**Colorado Springs Airport Advisory Commission Meeting
To Be Heard February 24, 2021
Land Use Review Item #03**

EL PASO COUNTY BUCKSLIP NUMBER(S): PPR212 TELECOMMUNICATIONS TOWER DEVELOPMENT PLAN AMENDMENT		TAX SCHEDULE #(S): 6512300001
DESCRIPTION: <p>Request by on behalf of Tower Engineering Professionals, Inc., for a modification to an existing T-Mobile telecommunications tower. The modification includes removing (3) antennas and installing (6) new antennas and related tower equipment on existing 121' monopole. The modification also includes removal of a cabinet and installation of (2) new cabinets and related ground equipment. The modification will not change the existing height of the tower. The property is zoned A-5/CAD-O (Agricultural with Airport Overlay). The site is located southwest of Bradley Road and Grinnell Street.</p> <p><i>Review Note:</i> <i>The approval of the T-Mobile modification to install new antennas was reviewed with recommended conditions by the Commission in October 2019</i></p>

CONSTRUCTION/ALTERATION OF MORE THAN 200 FEET ABOVE GROUND LEVEL? No	DISTANCE/DIRECTION FROM COS: 2.8 miles southwest of Rwy 35L	
TOTAL STRUCTURE HEIGHT AT THE ESTIMATED HIGHEST

TOWER ELEVATION

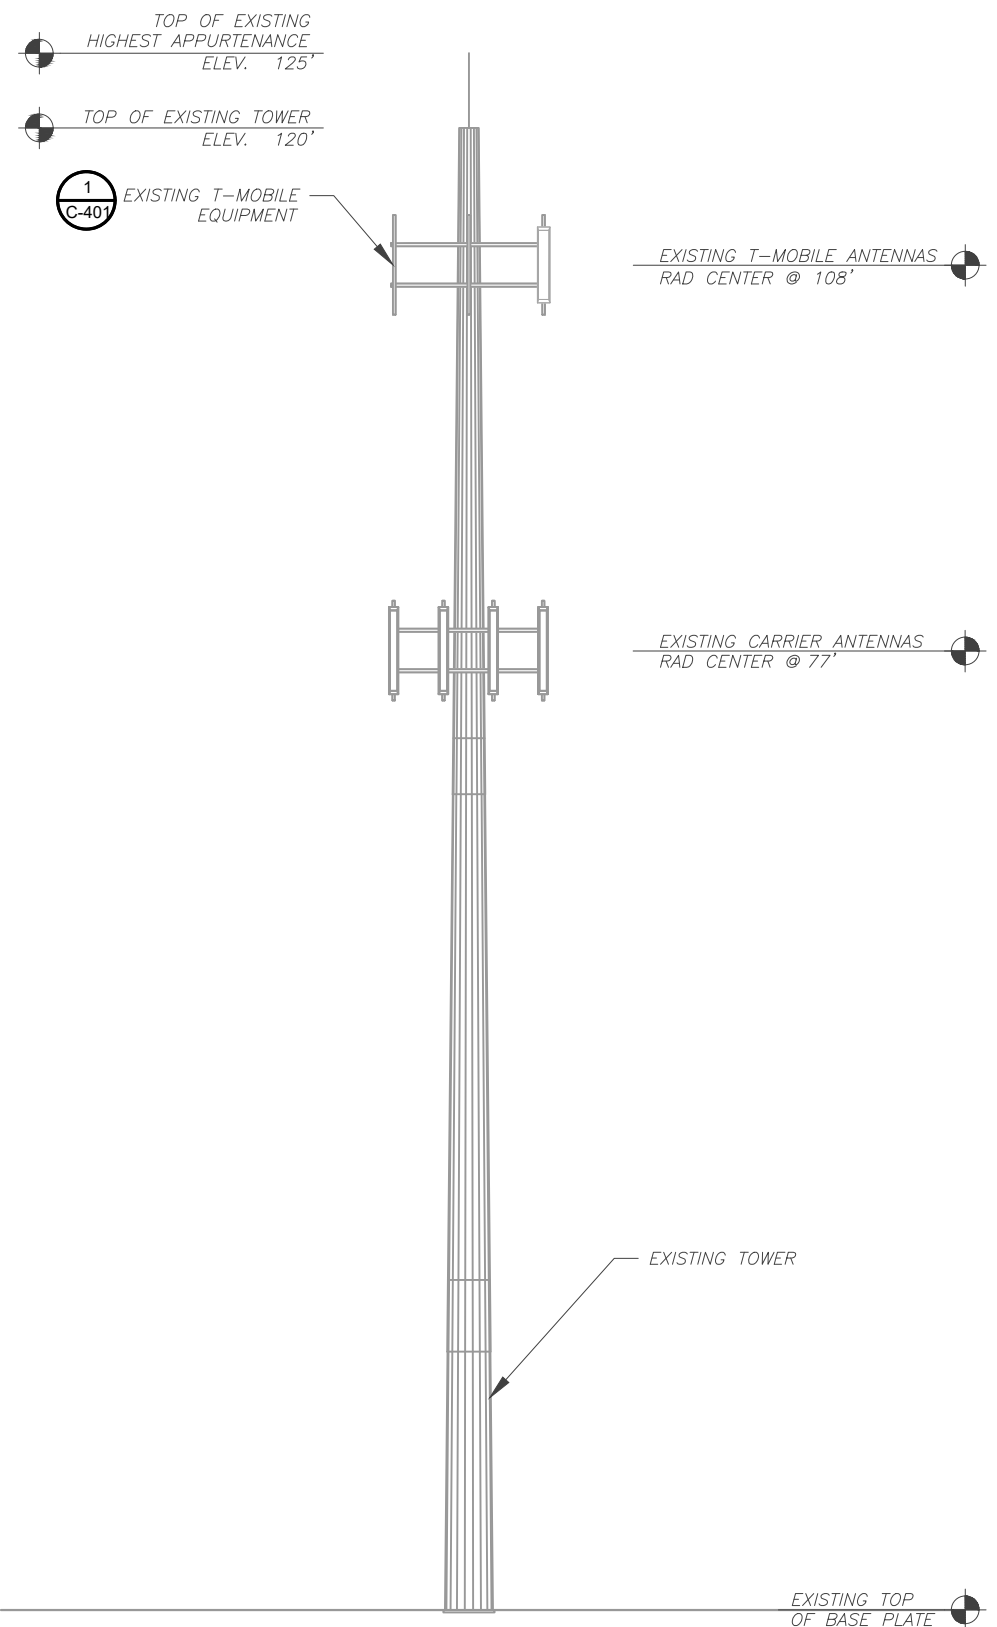
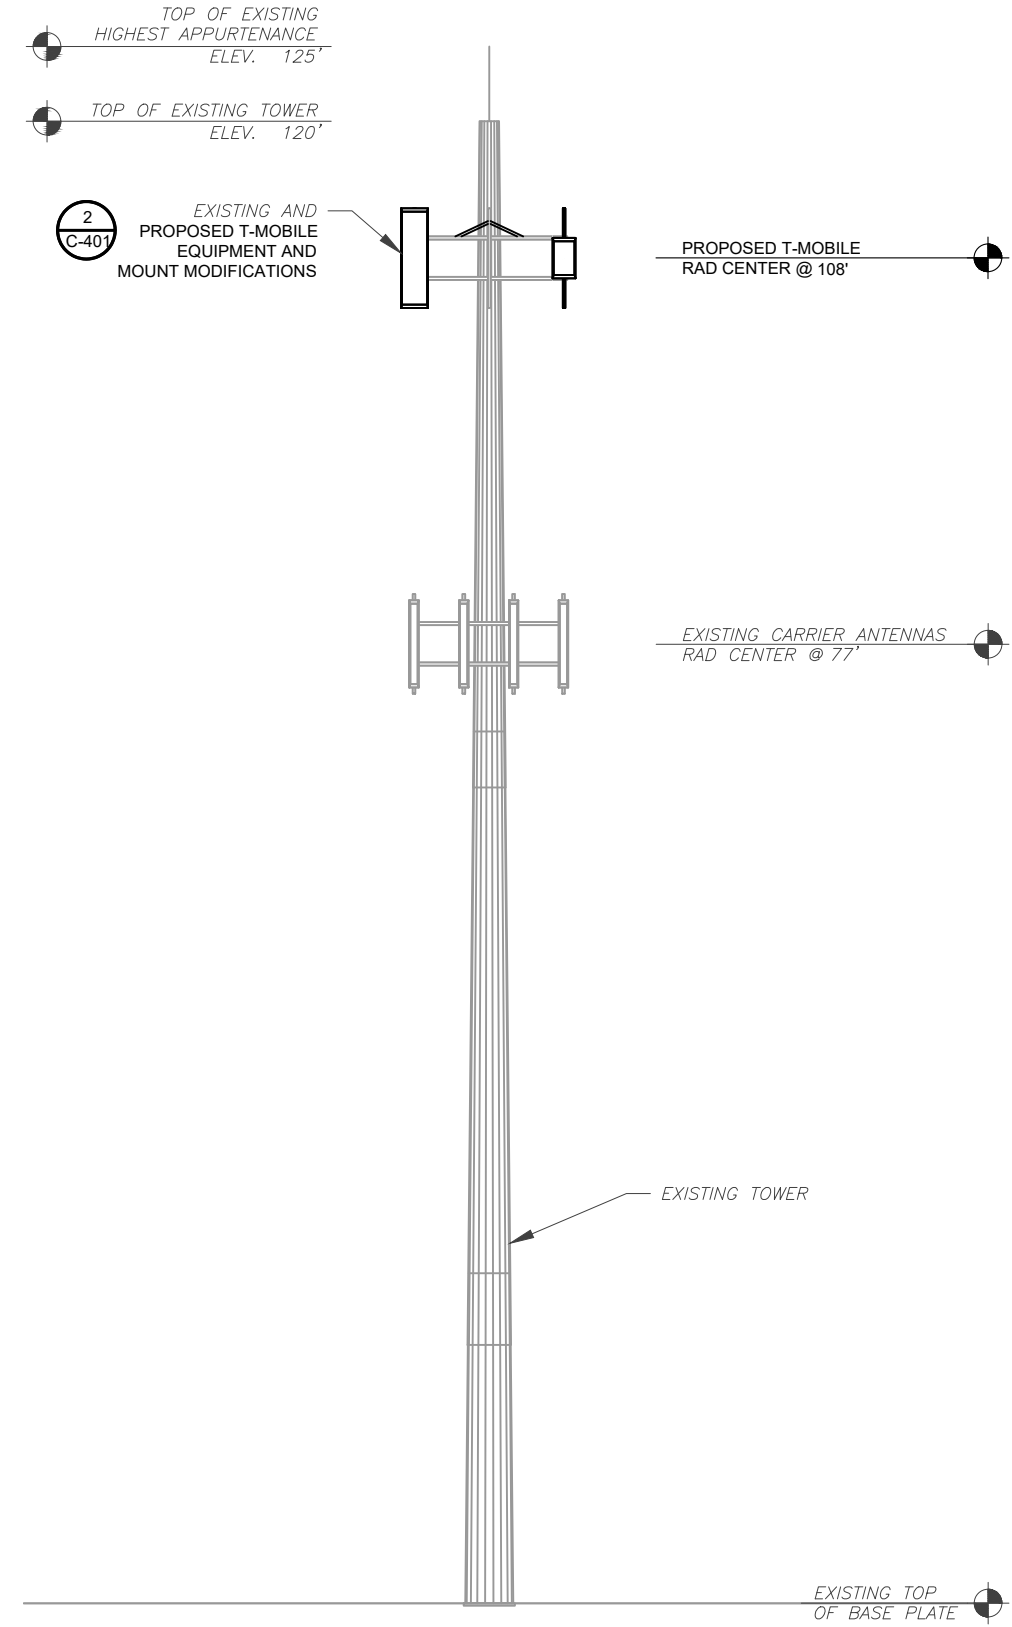
- **Avigation Easement:** An avigation easement is requested or provide proof of previous recording (book/page or reception number).
- **FAA 7460-1:** If the proposed equipment does not use one of the pre-approved frequency bands contained in the following: https://oeaaa.faa.gov/oeaaa/external/content/CVCC_FR_2007.pdf, the applicant is to file an airspace evaluation case with the FAA for the purposes of a frequency analysis and provide the results to the Airport before the commencement of construction activities.

- **FAA Form 7460-1:** If use of equipment (permanent or temporary) will exceed 140 feet above ground level in height at this site, the applicant is to file an airspace evaluation case with the Federal Aviation Administration (FAA) and provide the results to the Airport before the commencement of construction activities; FAA's website (<https://oeaaa.faa.gov/oeaaa/external/portal.jsp>).
